## Engineers Comments Regarding Surface Water Drainage

| <b>Application Reference:</b>   | Y/9/25/DOC                                                                                                                                                                                                                                                                                                                                                | <b>Reviewer Reference:</b> | ADC/EXT5/AF |
| <b>Site Name:</b>               | Fleurie Nursery Lake Lane Barnham PO22 0AL                                                                                                                                                                                                                                                                                                                |                            |             |
| <b>Application Description:</b> | Approval of details reserved by condition imposed under reference Y/26/24/PL relating to condition number <b>4 - surface water drainage scheme, condition number 5 - discharge flows to watercourses, condition number 6 - maintenance and management of the s

PROPOSED BAGWORK HEADWALL FOR FW DRAINAGE  
(scale 1:20)

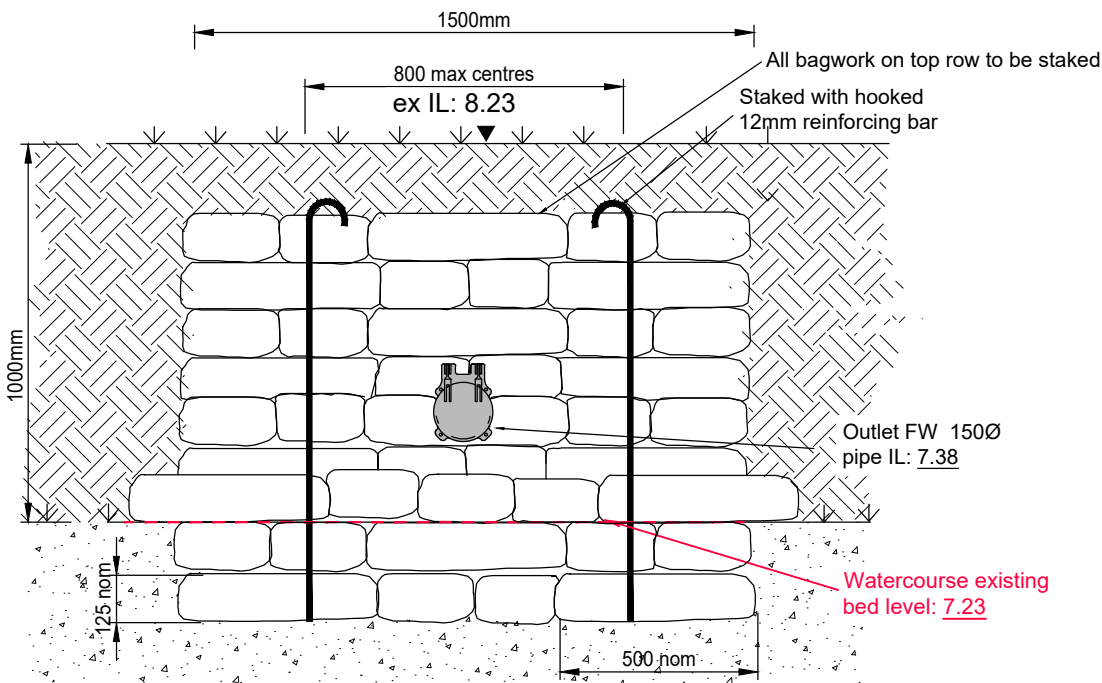
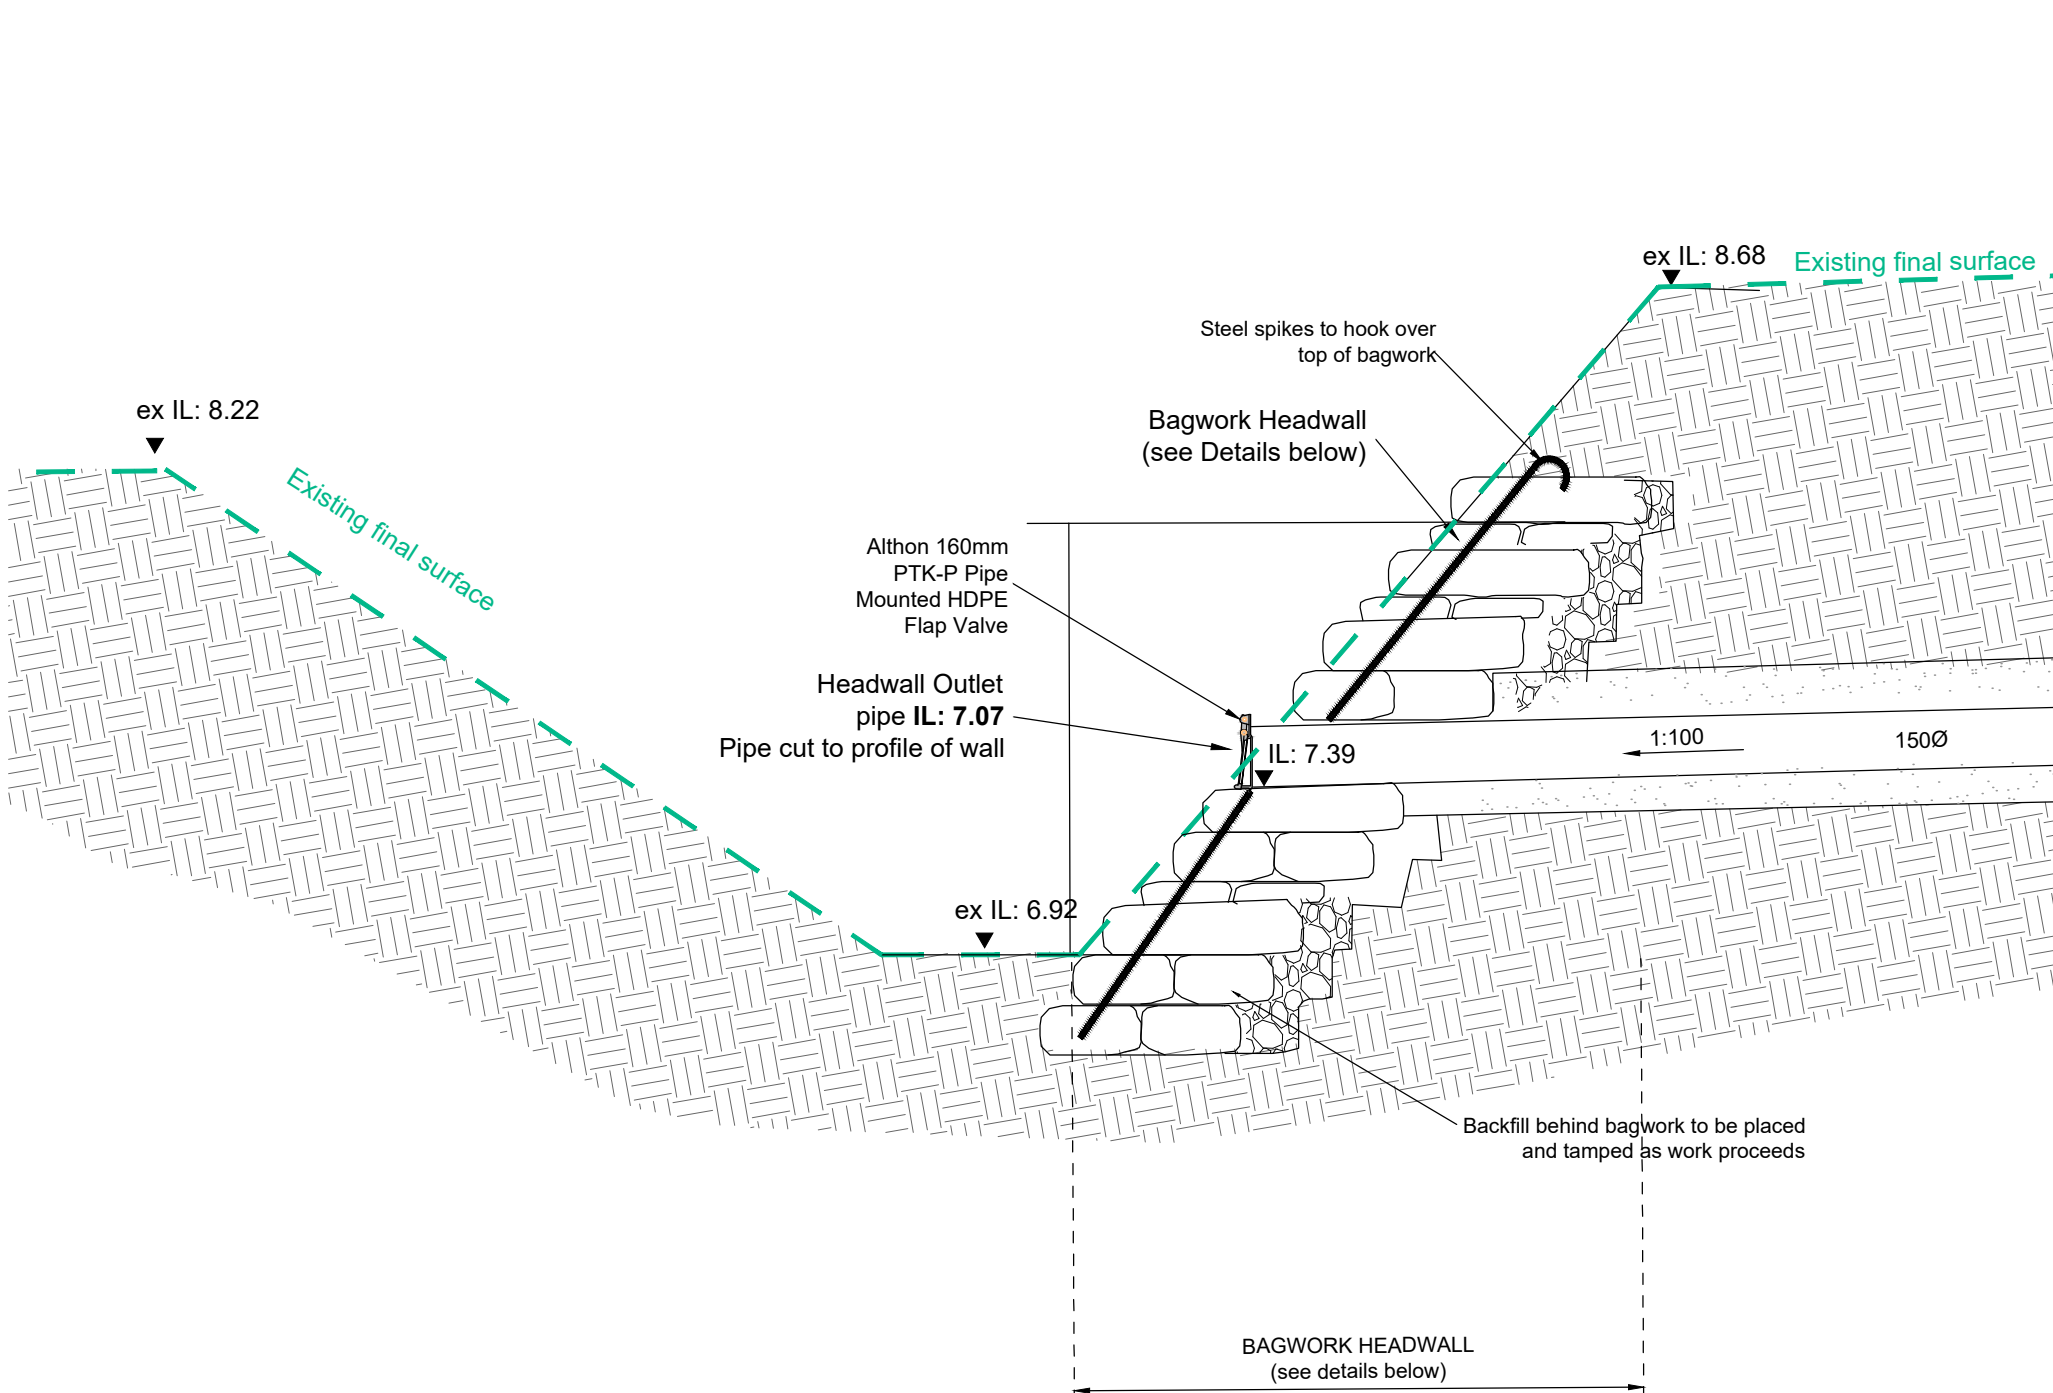
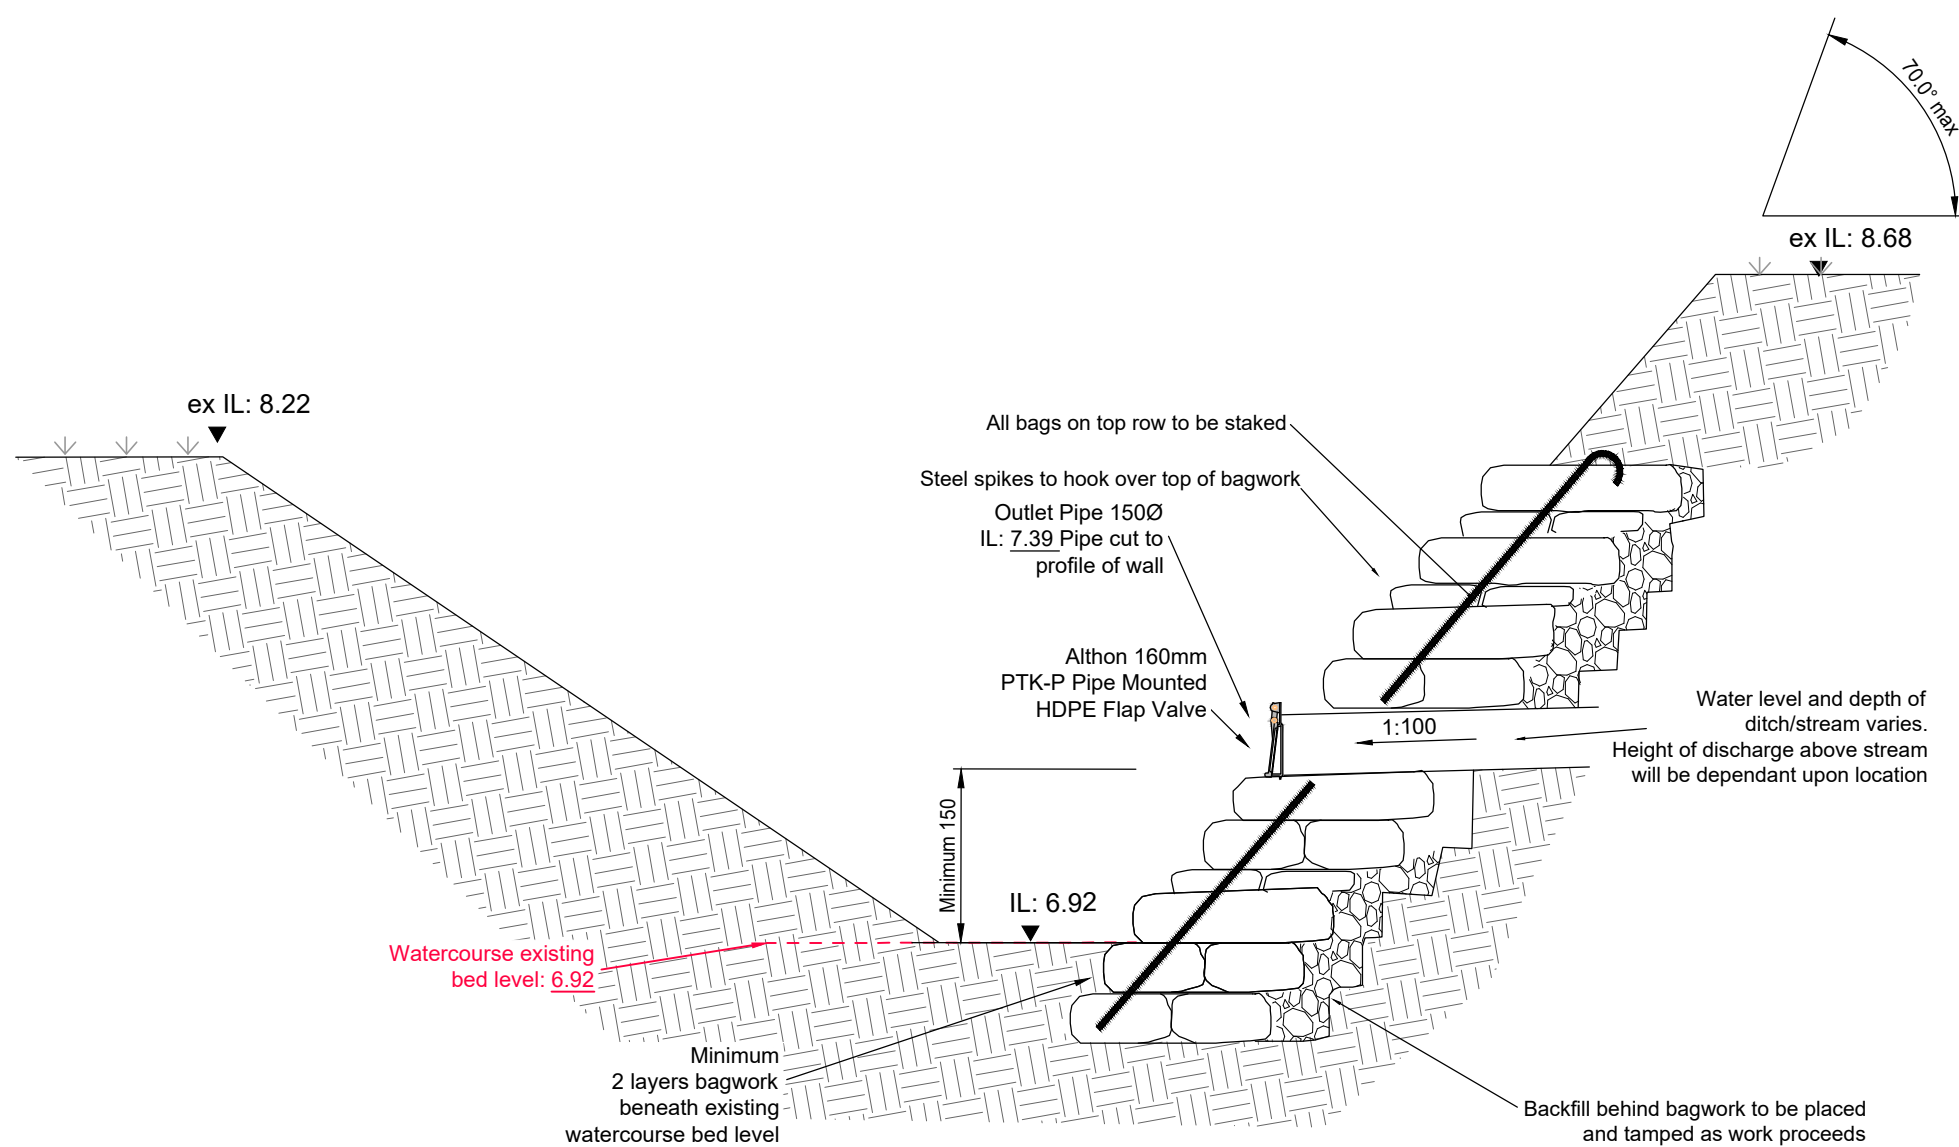
| 13. | <p>Please remove the standard (non-site specific) headwall details from C2904-P-501. These contradict the OWC drawings which are more detailed and site specific.</p> <p>Designers response<br/>26/03/2025<br/>Headwall detail has been removed.<br/>It should be noted that OWC drawings have been issued</p> | <p>Noted. Comment closed.</p>                                                              | COMMENT CLOSED |  |  |

DRAWN	KCK	ENGINEER	TZ	CHECKED	CS	APPROVED	CS
DATE	DECEMBER 2023	SCALE @ A1	1:200				
JOB No.	C2904	STATUS	P	DRAWING No.	101	REV.	P4

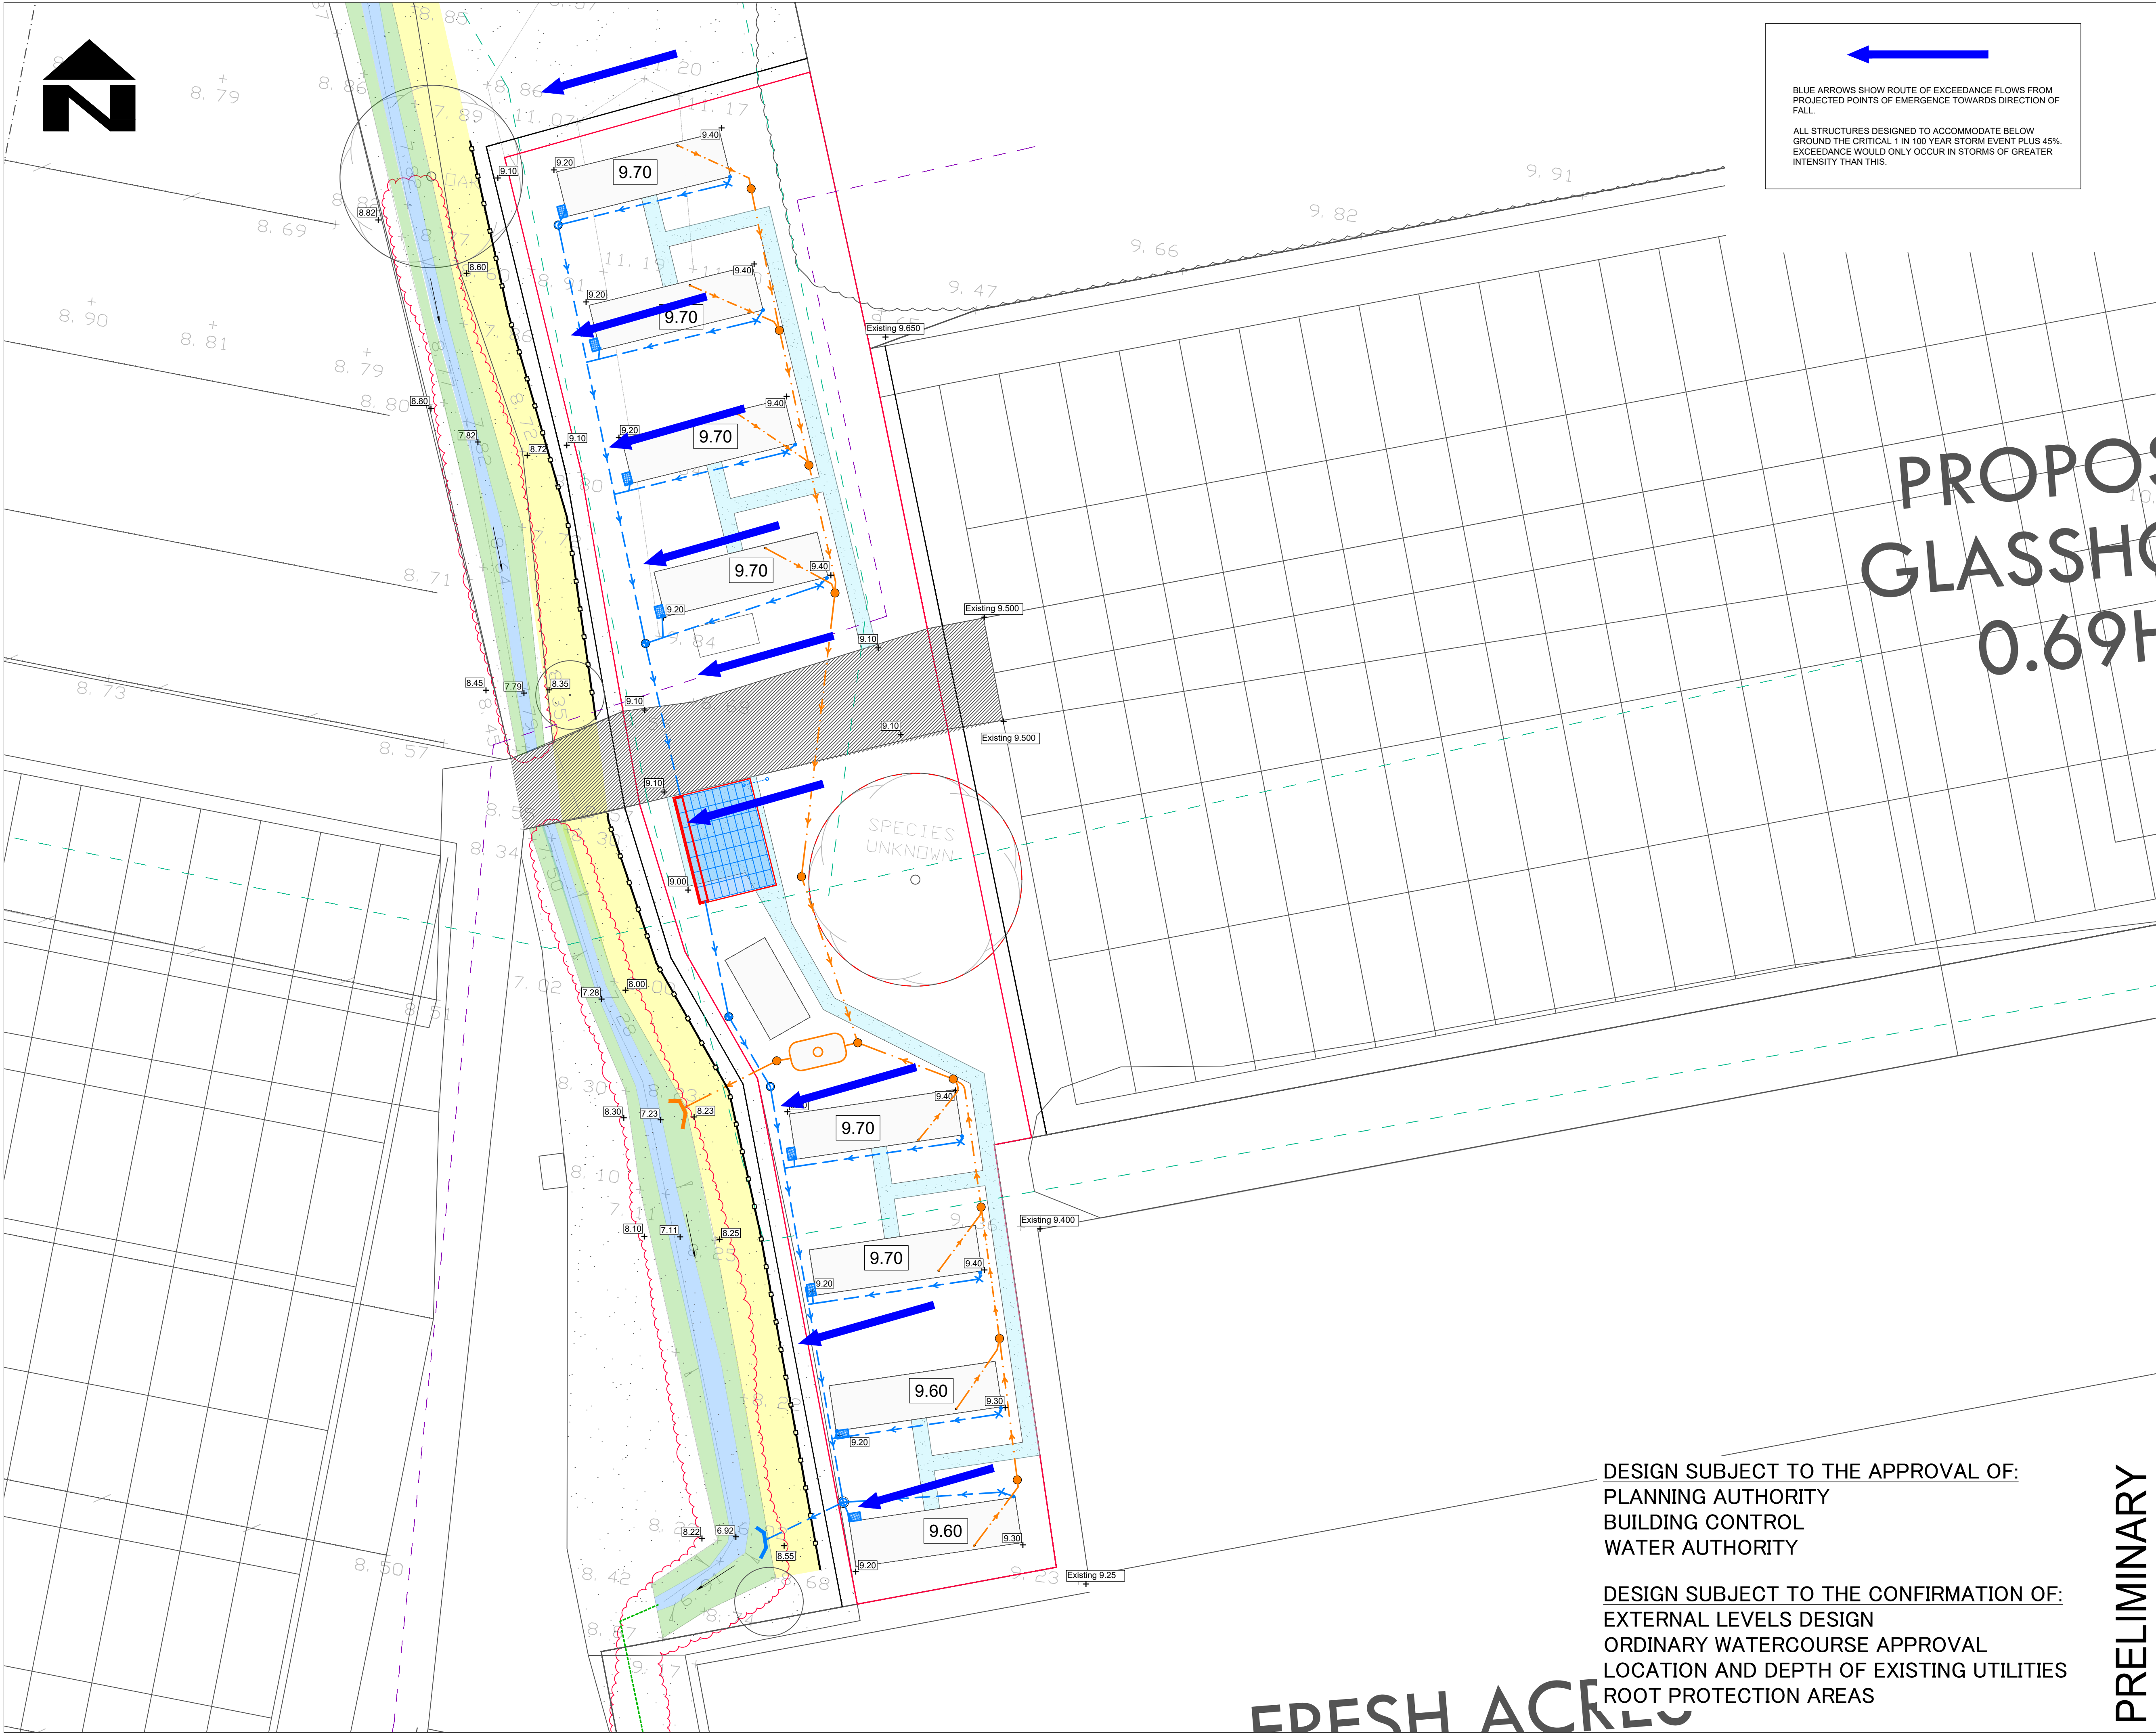
| 4. | <p>Please correct discrepancies between cover and invert levels on the plans and the calculations.<br/>[It is acknowledged that this is unlikely to affect the design.]</p> <p>Designers response<br/>26/03/2025<br/>Discrepancies are now updated, please find the revised drainage plan and drainage calculations attached.</p>                                                                                                                                          | Cover levels for S3 and S4 differ. Please adjust. | Updated.              | Drawing revision C2904<br>P101 rev P5 acceptable.<br><b>Comment closed.</b> |  |

| 11. | <p>The orifice for S5 is described on the layout as being 500mm diameter. This is assumed to be a typo (confused with the chamber diameter), please correct.</p> <p>Designers response<br/>26/03/2025<br/>Orifice chamber diameter has been updated to 600mm diameter and orifice diameter to 20mm.</p>        | <p>Orifice chamber is shown as 900mm diameter. 20mm orifice noted.<br/>Comment closed.</p> | COMMENT CLOSED |  |  |

|     | <p>and foul drainage north of S4 and west of F6. Please adjust the design, if possible, to minimise this risk.</p> <p><b>Designers response</b><br/>26/03/2025<br/>Clash has been reviewed and a separate note indicating proposed SW and FW pipes invert levels is now indicated.</p>                                                                                                 | but achievable. Comment closed.                                                                                                                                                                                                                                         |                       |                                                                                                                               |  |

Sel Controflow 600-900Ø Orifice Chamber

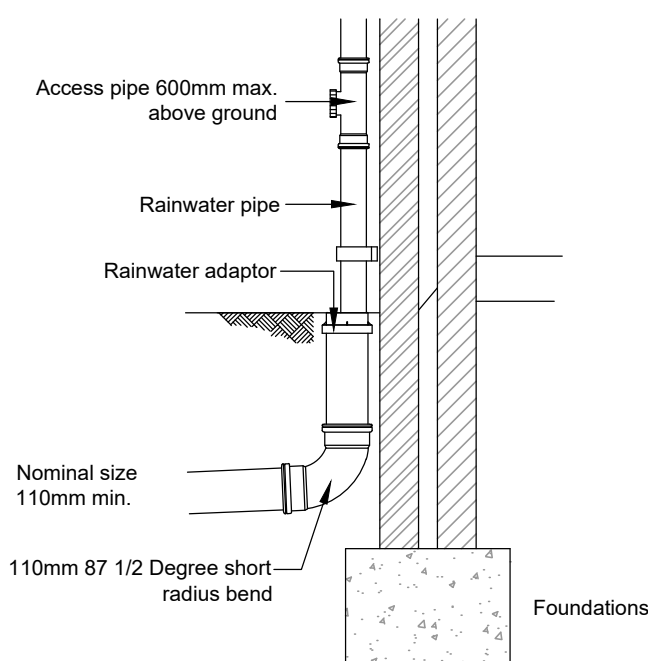
| 14. | <p>Please detail the overflow level of the Sel Controflow 500 Orifice Chamber.</p> <p>Designers response<br/>26/03/2025<br/>Overflow level is now indicated on orifice chamber detail.</p>                                                                               | <p>It is noted that the overflow level of 9.150 is higher than manhole S3 cover level (9.00) upstream, so in the event of a blockage at the orifice, excess water <b>may</b> overflow from S3 before the formal overflow at S5 operates. Please advise.</p> | <p>Updated. The overflow level has been lowered and is now set at 9.025.</p> | <p>Drawing revision C2904 P101 rev P5 has been adjusted to show an overflow level of 9.025. The construction details drawing should be updated to suit.</p> <p>The construction detail for the attention arrangement should demonstrate how the vent pipe outlet will be above the overflow level, or the overflow level reduced below the cover level for the storage.</p> |  |
